MS21010-V3-RoundaboutLightingPlan.pdf Markup Summary

Subject: Callout
Page Index: 2
Date: 8/22/2022 3:10:44 PM
Author: dsdrice
Color: ■
Layer:
Space:
Page Label: 2

Walker Roundabout North

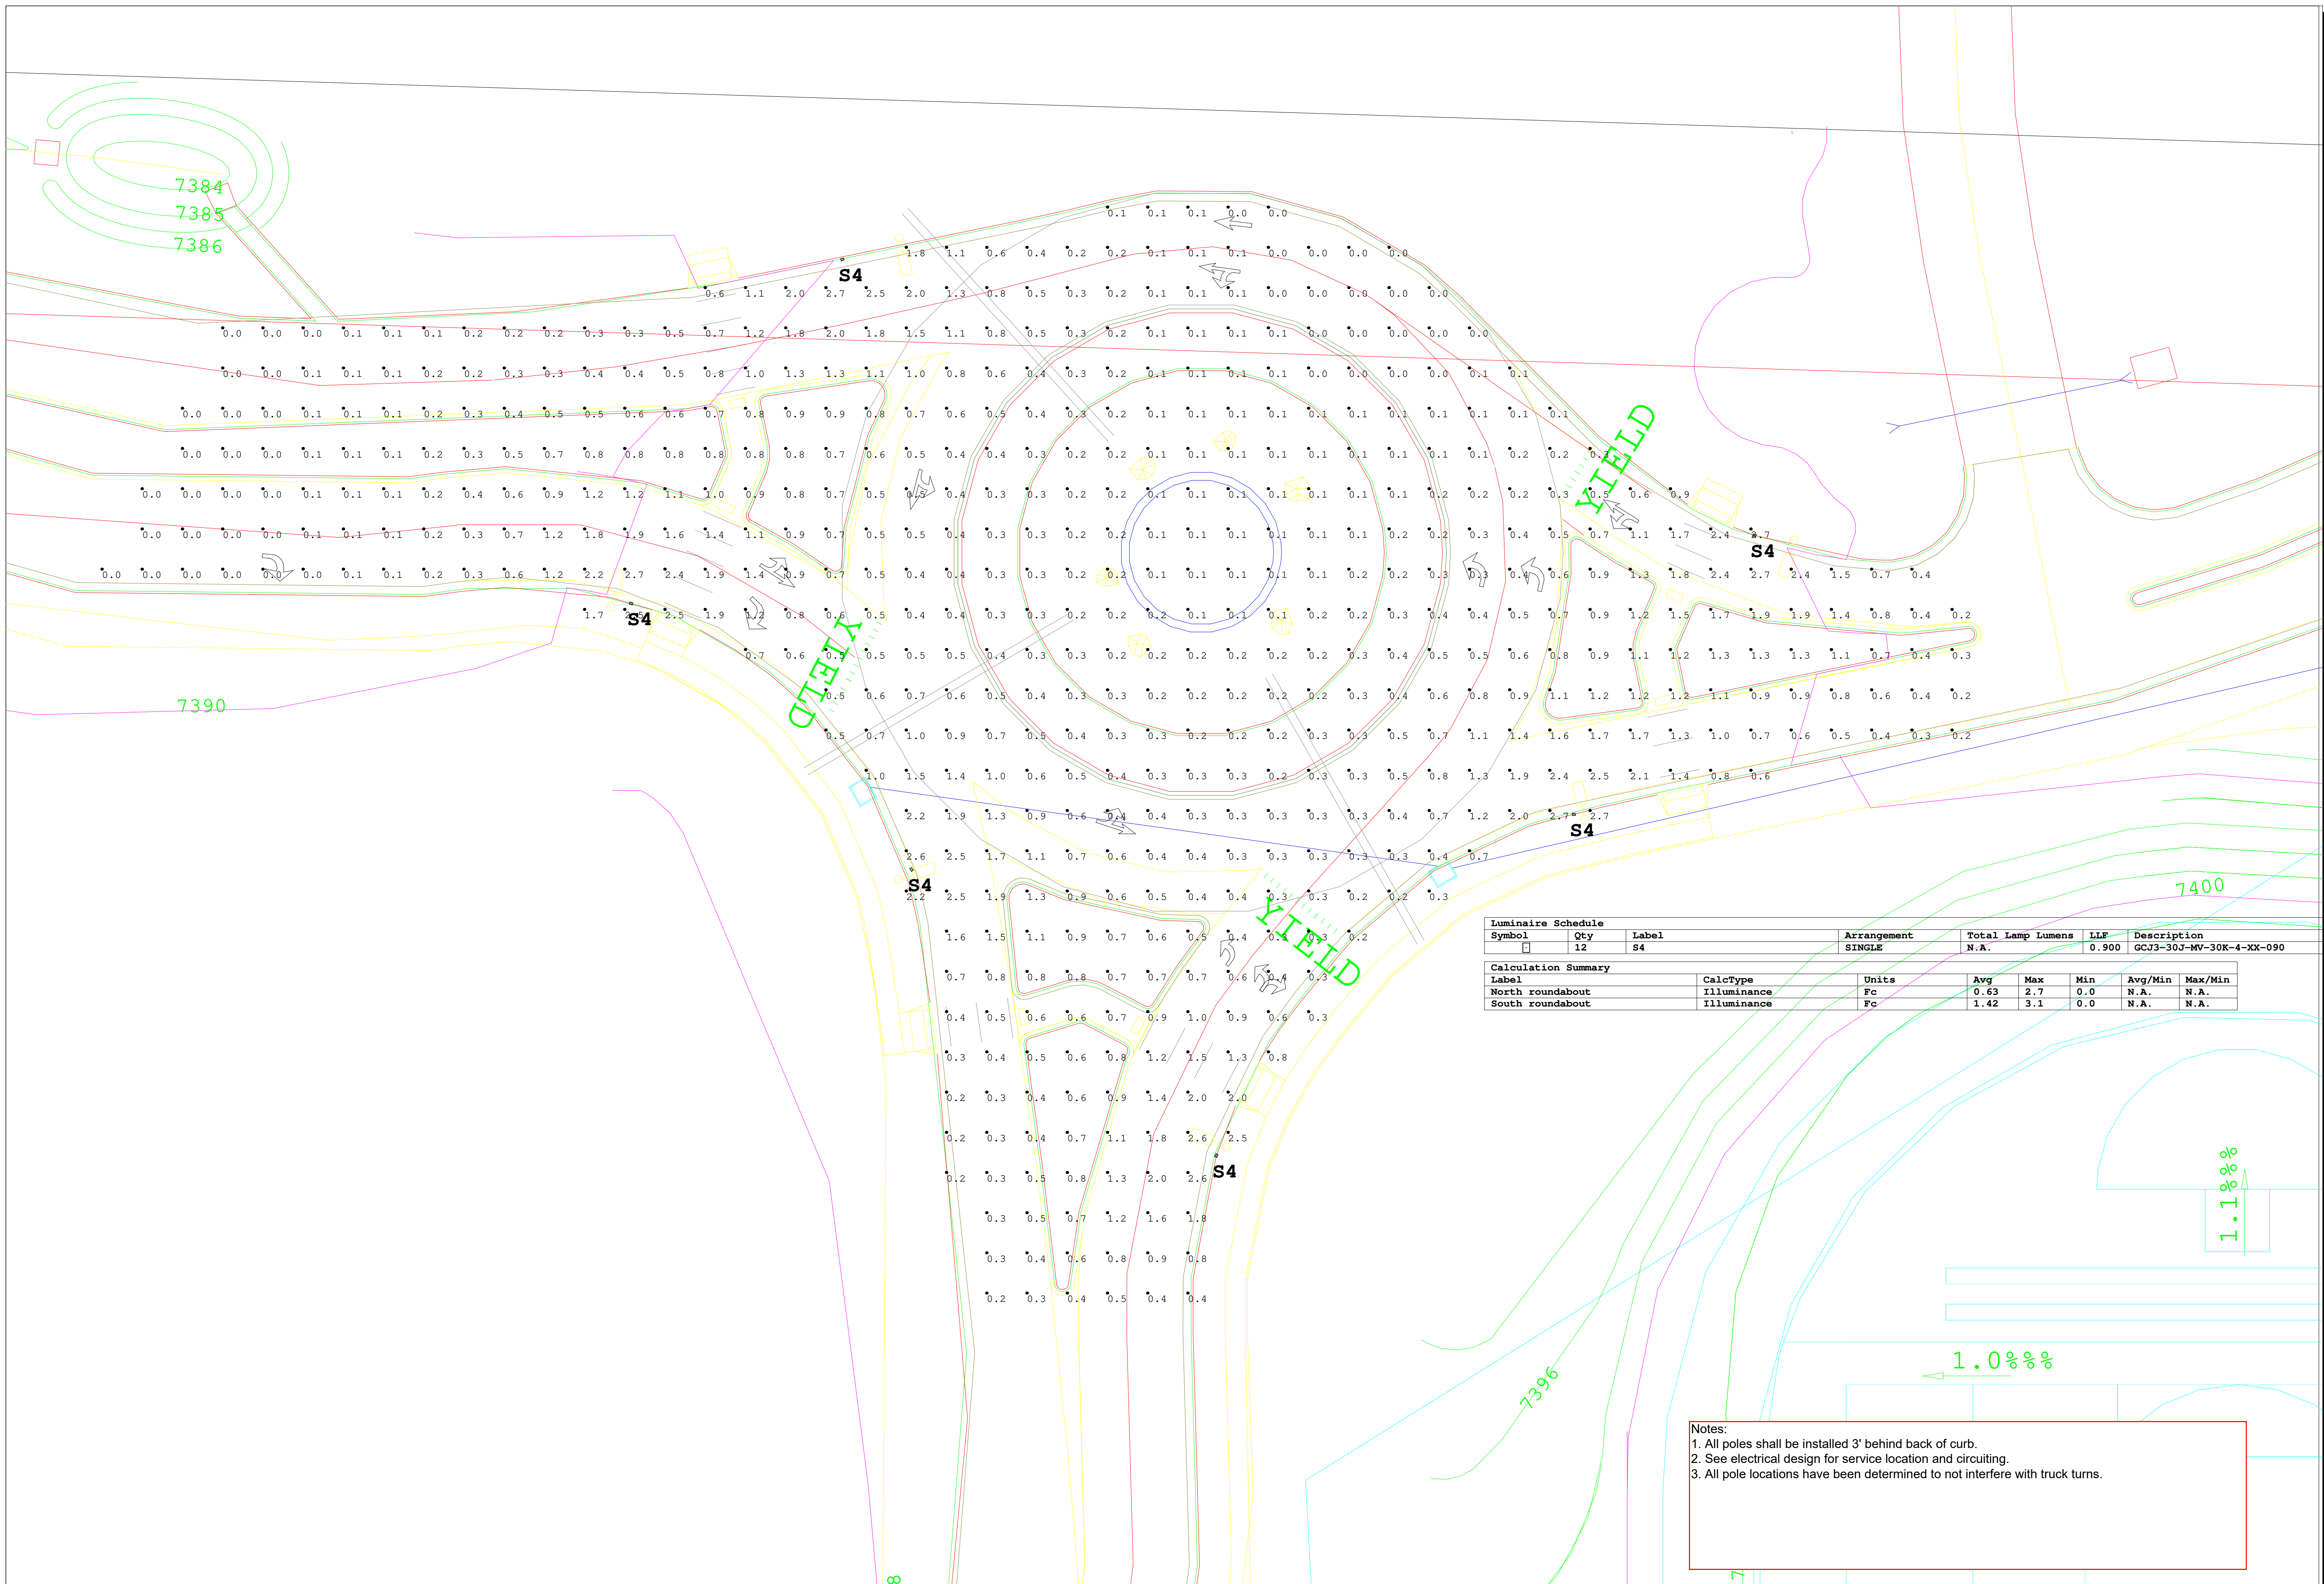
These are on the opposite side of the ped crossing needed
